Internal Ref: EXTERNAL/2025/0019

Inner West Council Response: SSD-96105713– 245 Marion Street, Leichhardt

Thank you for the opportunity to participate in the Planning Focus Meeting (PFM) on 20 October 2025. The comments below are offered in response to the request for Secretary's environmental assessment requirements (SEARs) for a State Significant Development Application (SSDA) and concurrent rezoning at 245 Marion Street, Leichhardt. Accordingly, this letter documents the views of Council officers, not of the elected representatives

Figure 11 Indicative Ground Floor Plan

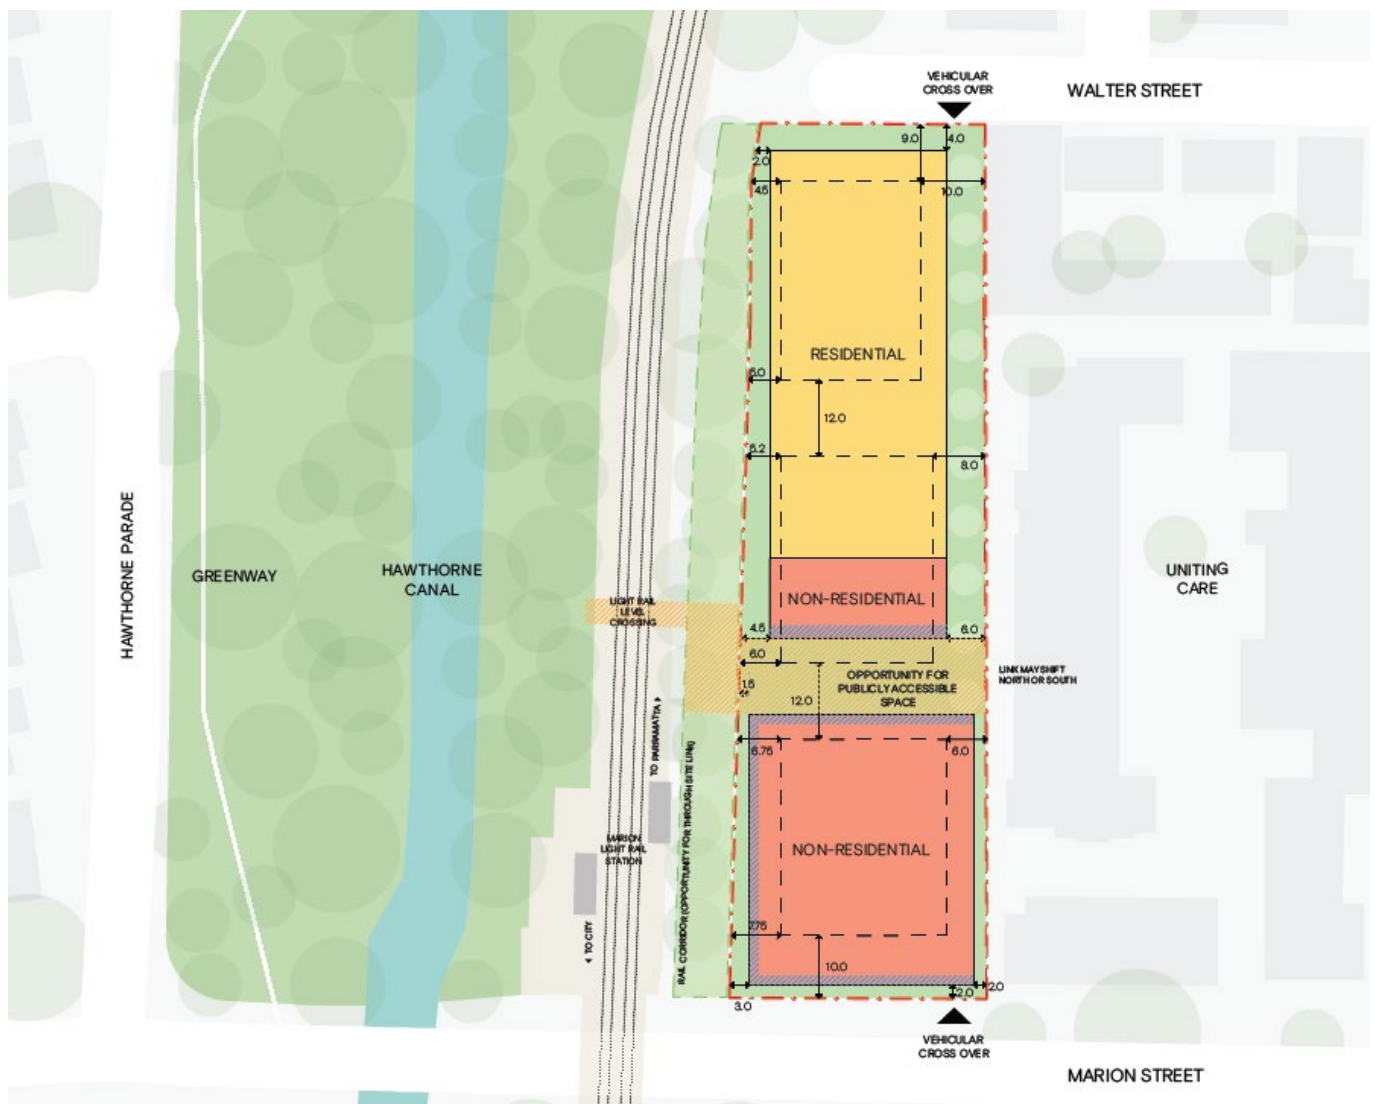
- The proposed publicly accessible space within the site does not align with key pedestrian corridors or destinations and is better suited for internal communal use.

- Publicly accessible open space should be located adjacent to the public domain—ideally fronting Marion Street—with strong visual and solar access.
- Council proposes a secondary GreenWay along the eastern side of the light rail, consistent with the GreenWay Master Plan. This link would facilitate pedestrian and cyclist connectivity between Marion Street and Walter Street. The site's 35–40m width is sufficient to accommodate this through-site link, a feasible building footprint, and the required building setbacks and separations.

- The proposed through-site link must be open to the sky and comply with the Crime Prevention Through Environmental Design (CPTED) principles including passive surveillance, activation, safety, visual access and lighting.
